**Planning Application Ref:** BR/229/17/PL (Prev BR/200/16/PL Withdrawn)

**Location :** Land rear of 41 to 47 Pevensey Road, Bognor Regis

**Description of works:** Construction of 4 No dwellings with access and parking arrangements.

Consultant Arboriculturist

DRAWING TITLE
Block & Location Plans and Site Section

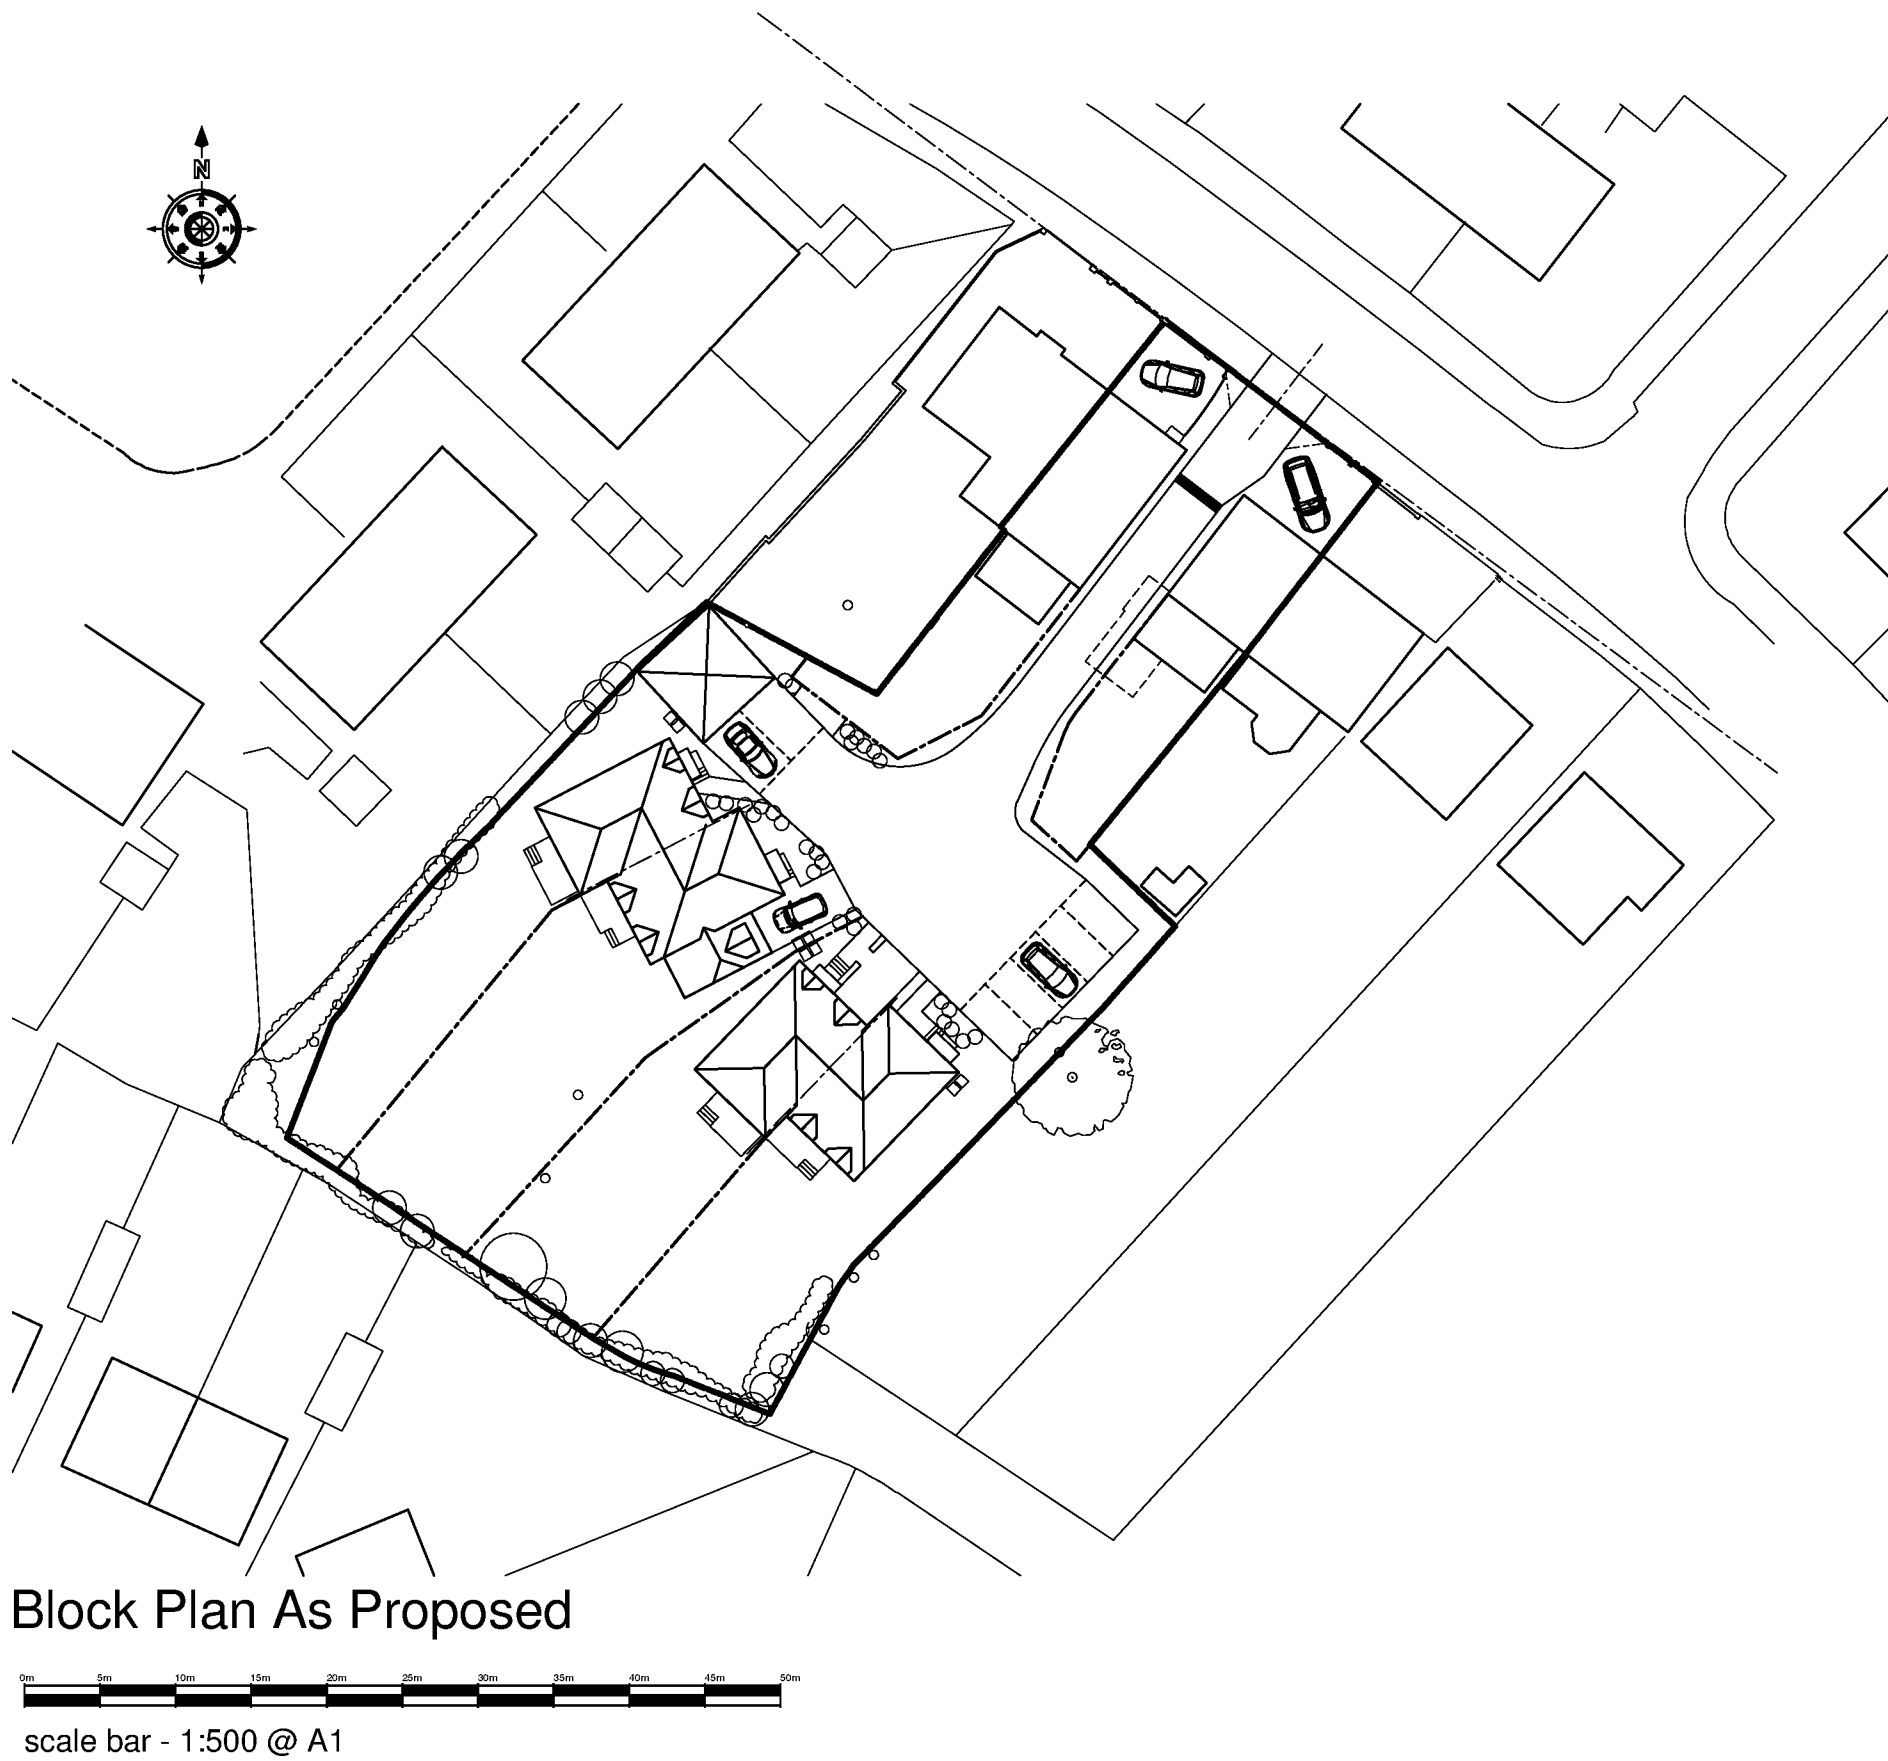
- The primary change to the layout as far as I can see is that Plot 4 has been moved outside of the RPA for trees 11 & 12 and the parking has been relocated along the eastern boundary in front of these two tree and within their RPA.

- The building on Plot 4 although further away will still be shaded by off-site trees in the garden of No 39 ( primarily TPO trees T11/12 & T2) so there will still be pressure to prune or fell that would be difficult to resist on application to prune back from the garden by the new owners of Plot 4.

- On re-assessment of Plot 1 I also note that it has a very narrow garden and about 50% of this will be directly shaded by trees 19 & 20 both of which are not yet fully grown so the problem can only intensify year on year and once again these will be under pressure from the new occupants for pruning or felling which will be difficult to resist. Only T20 is TPO'd here so T19 could be removed without reference to the local authority and we would have difficulty in resisting an application to prune T20. This situation would be eased considerably if we were looking at three dwellings and not four here – this would also allow the parking to be re-designed to be totally outside of the RPA's of trees T11 & T12.

- Whilst I accept that there is provision within BS5837 to mitigate the effects of the car parking within the RPA's of T11 & T12 I would much rather see them design this out of the scheme rather than 'make it fit' by mitigation. I am also not convinced that the levels would allow the proposed 'No Dig' situation to be applied here and would wish to see east /west cross section drawings submitted to prove that this can really work.

- Even with the amendments to layout that have improved matters I still have concerns over intense shading of gardens and also the viability of applying a 'No Dig' situation adjacent to Trees 11 & 12 for the parking bays.
- I therefore **OBJECT** to this scheme as it still represents a situation where pressure to 'Prune or Fell' valued trees in the landscape is inevitable.
